Subject: Rezoning Petition Review

Date of Review: January 24, 2023

Rezoning Petition #: 22-139

Proposed Zoning: UR-2(CD)

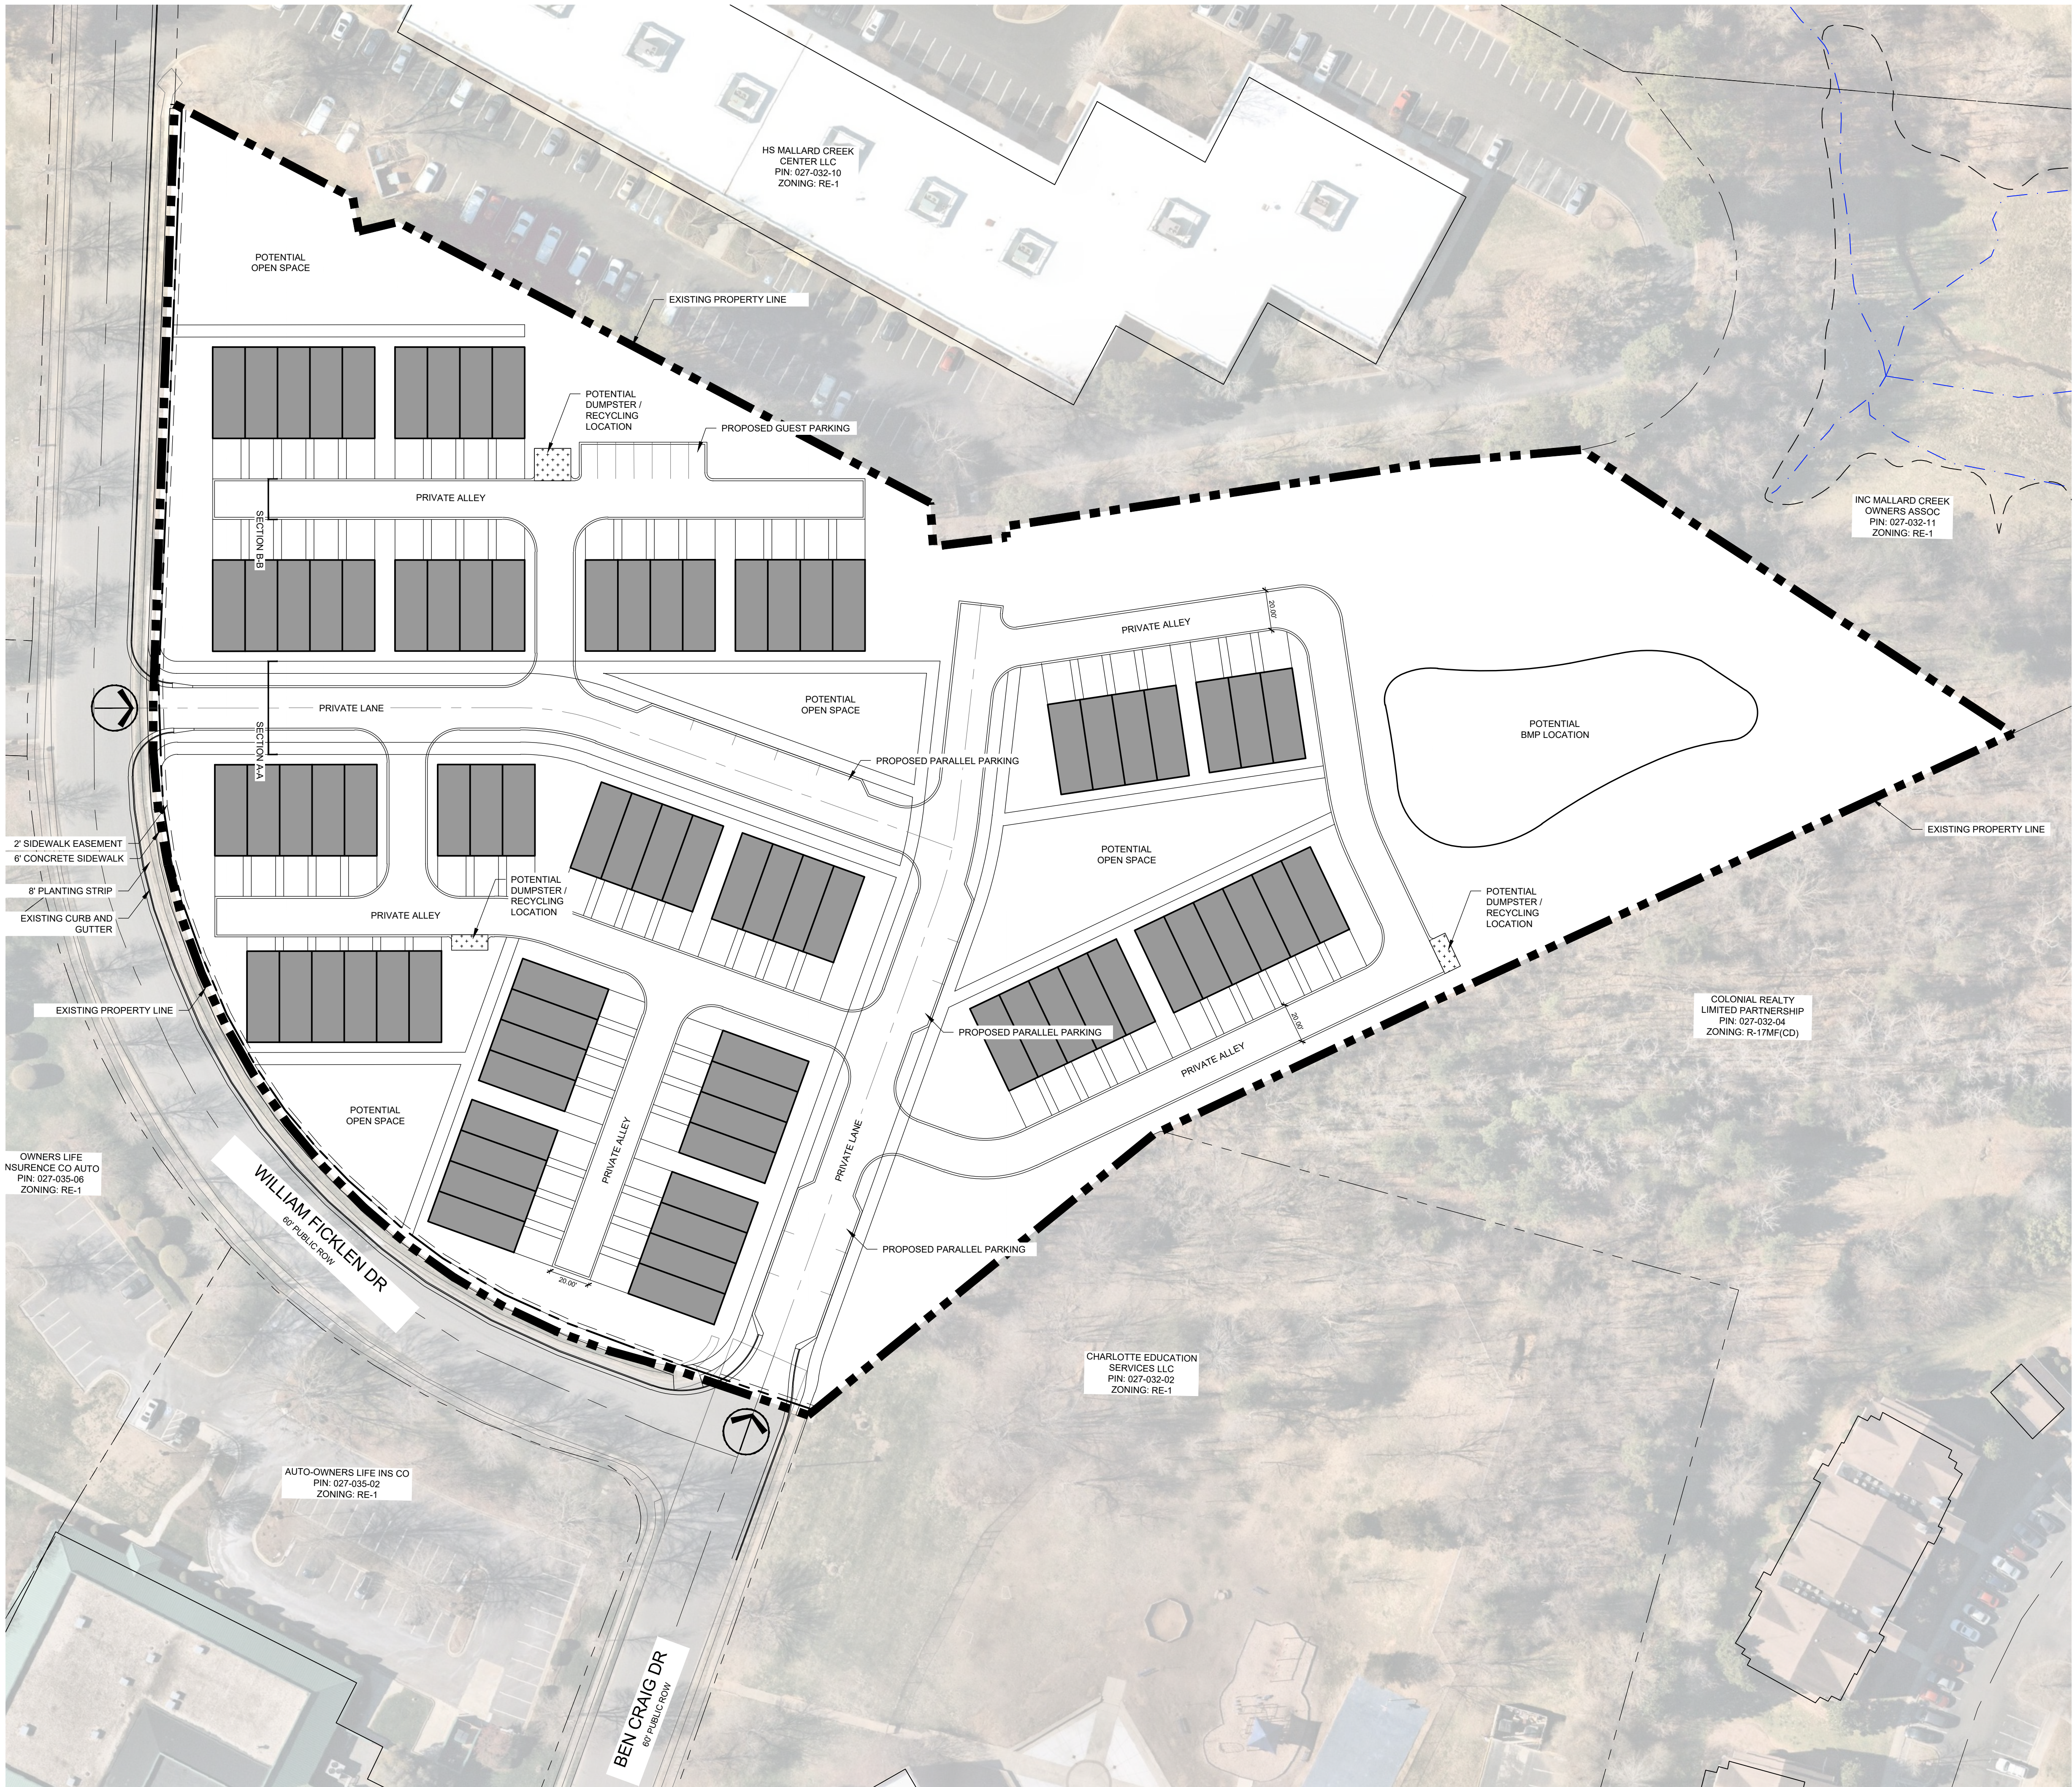
Please show and label potential 50' Undisturbed Post Construction Stormwater Ordinance buffer on the site plan and adjust construction limits to comply with buffer requirements.

The rezoning plan proposes several encroachments into SWIM and/or Post Construction Stormwater Ordinance stream buffers. Any increase of impervious area within such buffers may not be allowed and is not approved with the rezoning process. Please include the following note under Environmental Features: "Development within the SWIM/PCSO Buffer shall be coordinated with and subject to approval by Charlotte-Mecklenburg Storm Water Services and mitigated if required by City ordinance." Please note Stream Delineation Reports are subject to review and approval by Charlotte Storm Water Services.
